Inspector's Report ABP 304774-19.

Whether the decorative works to the front elevation of the Royal Irish Yacht Club, Harbour Road, Dún Laoghaire is or is not development and is or is not exempted development.

Royal Irish Yacht Club, Harbour Road, Dún Laoghaire, Co. Dublin.

ELEVATION PRIOR TO PAINTING

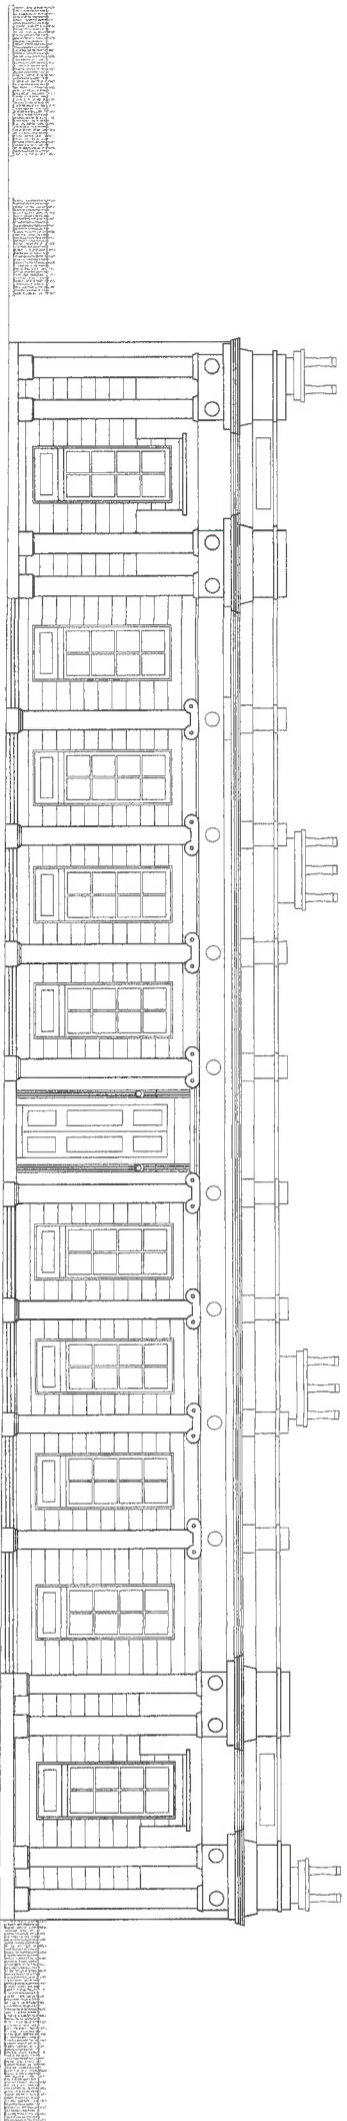
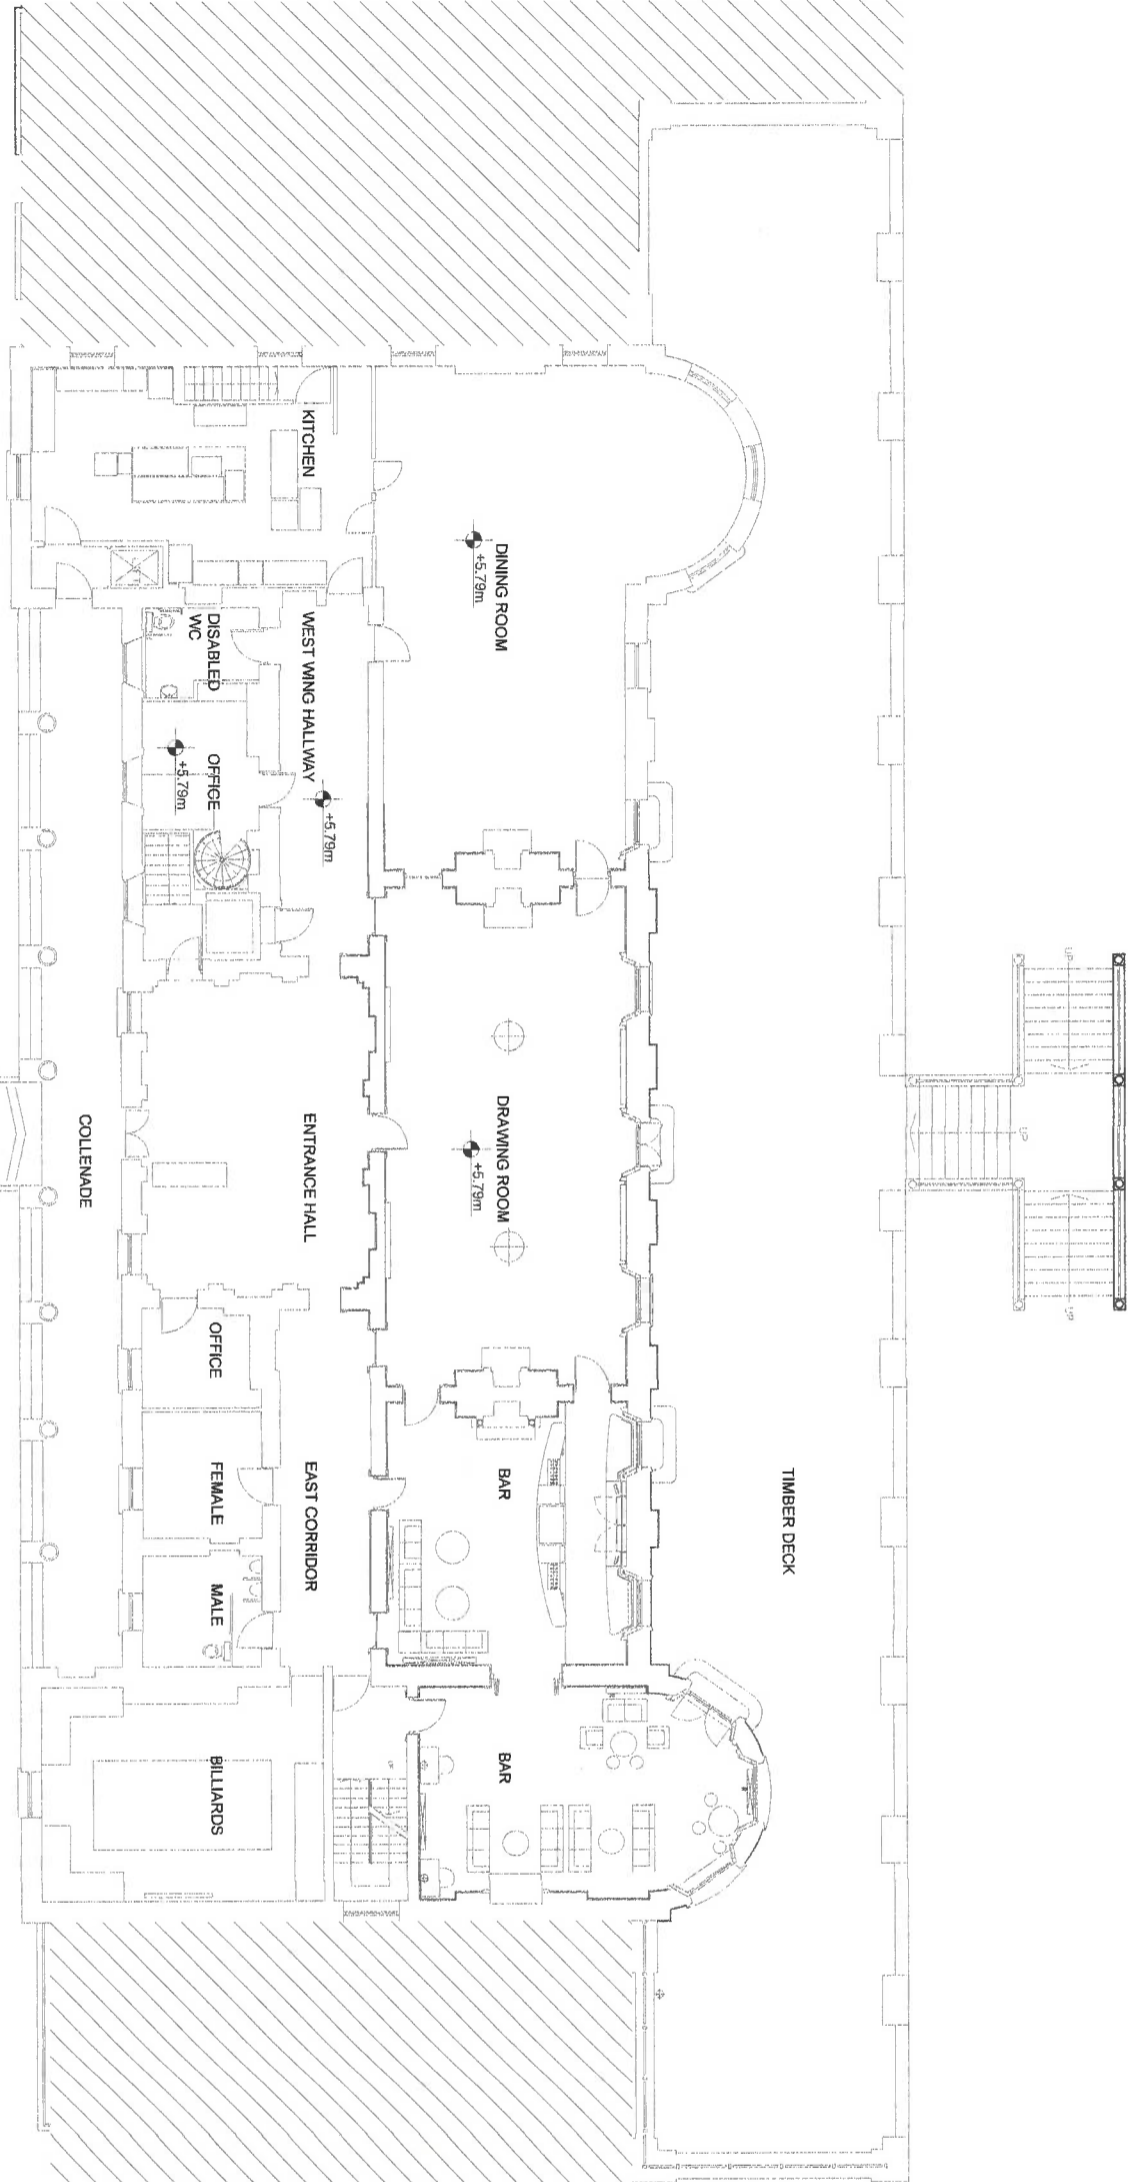
8.2.6. I would be of the opinion that the uniform colour of the exterior of the building allows the architectural features as detailed above to be viewed cohesively as opposed to the emphasis being placed on features which have been painted a contrasting colour such as the subject blue-grey colour to the walls of the entrance portico. The simple neo-classical design aesthetic of the Victorian building is characterised by the uniformity of the exterior paint finish in an off-white colour pallet. This has been a historical and consistent characteristic of the exterior of the Royal Irish Yacht Club. Furthermore, this is also characteristic of other Victorian seafront properties within Dún Laoghaire many of which are Protected Structures. Accordingly, the painting of

the subject walls within the portico of the building in the contrasting blue-grey colour would materially alter the character of the exterior of the building.

- 8.2.7. In my opinion the works undertaken to the Protected Structure the subject of this Referral, further to Section 57(1) of the Planning and Development Act 2000 as amended, do not constitute 'exempted development' as these works to the Protected Structure, the Royal Irish Yacht Club 'materially affect the character of the structure', because the uniform off-white paint finish to the exterior of the building and specifically the front façade of the building is an element of the structure which contributes to its special architectural interest.

on it by section 5 (3) (a) of the 2000 Act, hereby decides that the said works to the front elevation of the Royal Irish Yacht Club, Harbour Road, Dún Laoghaire, specifically the painting of all walls within the entrance portico a blue-grey colour is development and is not exempted development.
